**WEST SUSSEX COUNTY COUNCIL
PLANNING SERVICES CONSULTATION**

SUBJECT: AL/58/17/PL - Demolition of existing buildings, construction of 5No. live/work units & creation of new pastureland. This application is a Departure from the Development Plan.

Sack Lane Dairy, Sack Lane, Aldingbourne, PO22 9PD

2015/15/09

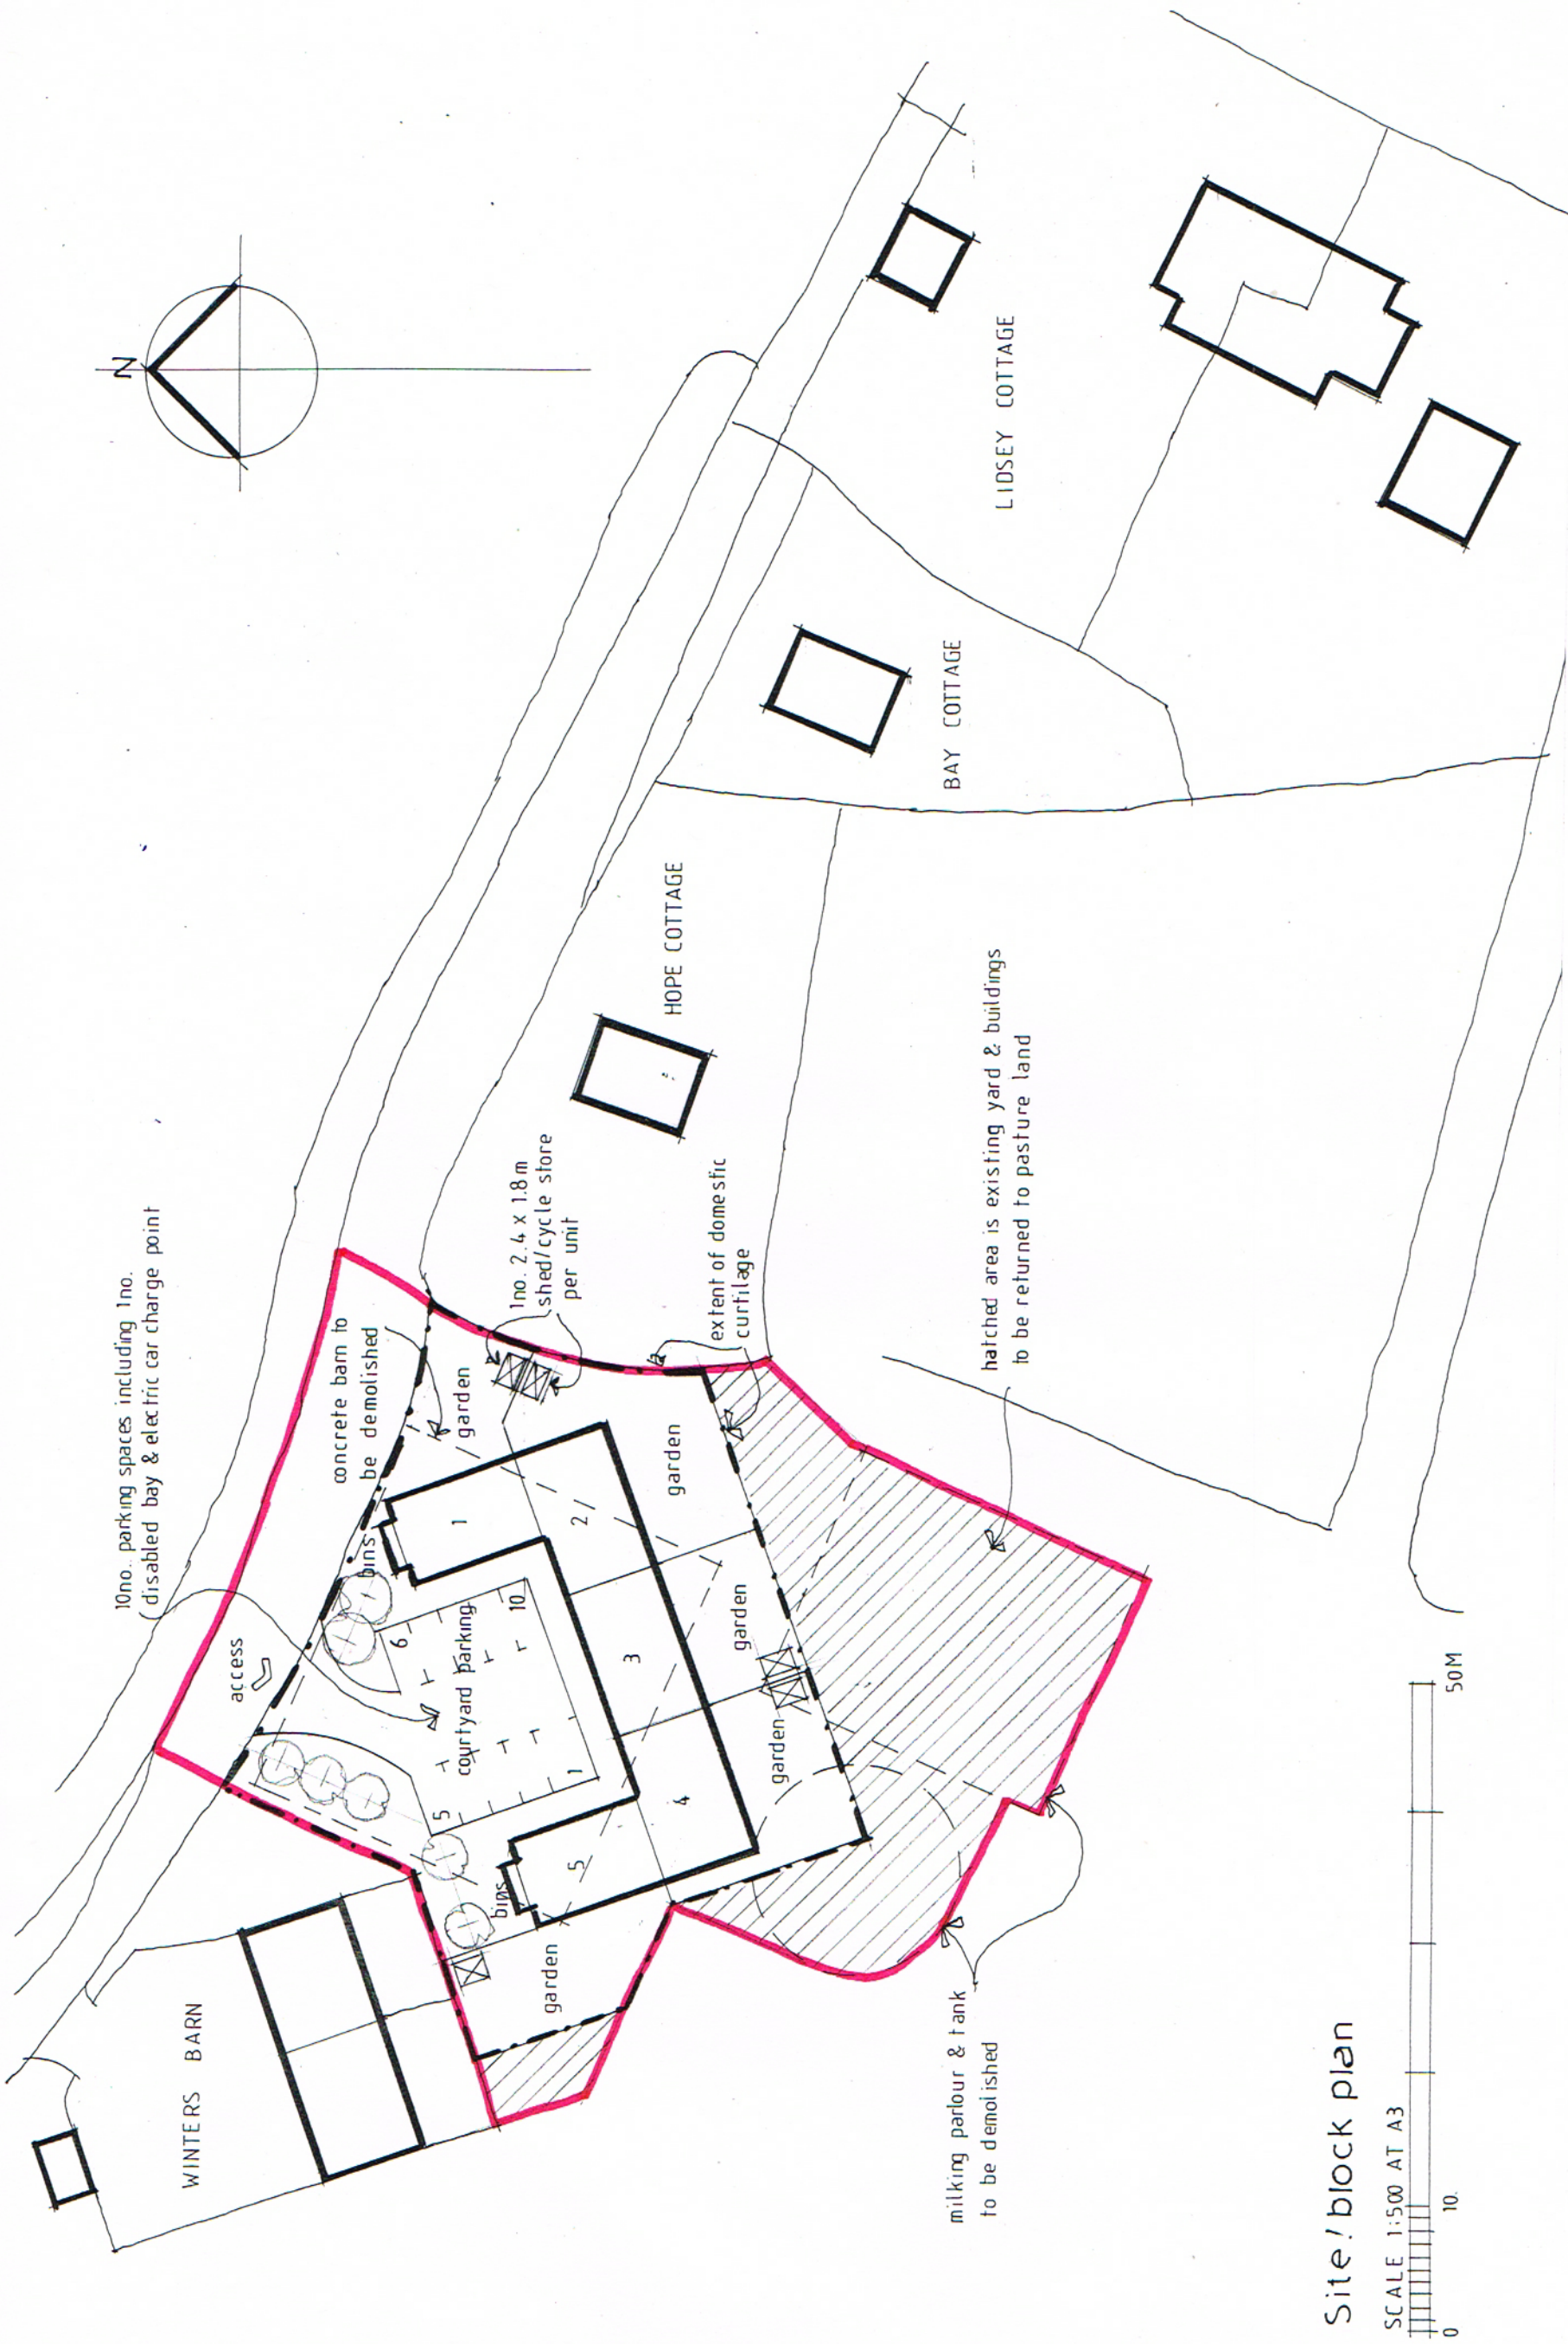
Each unit will be provided with two car parking spaces, one of which will be suitable for disabled users. In terms of quantity this would be considered appropriate to meet the day to day needs of the development, though an unallocated visitor parking/service space would be advised. The car parking spaces demonstrated meet the advised dimensions of 2.4 x 4.8 metres (3.6 metres width for disabled). With regard to turning, 6.0 metres manoeuvring room between the parking spaces is considered large enough to allow vehicles the provision to turn on site.

Providing they are secure and covered the cycle parking provisions indicated on site plan 2015/15/09 Rev B would be considered acceptable.

No anticipated highways safety or capacity concerns would be raised to this proposal. If the LPA are minded to grant planning consent the following conditions would be advised:

- Cycle Parking
- Vehicle Parking
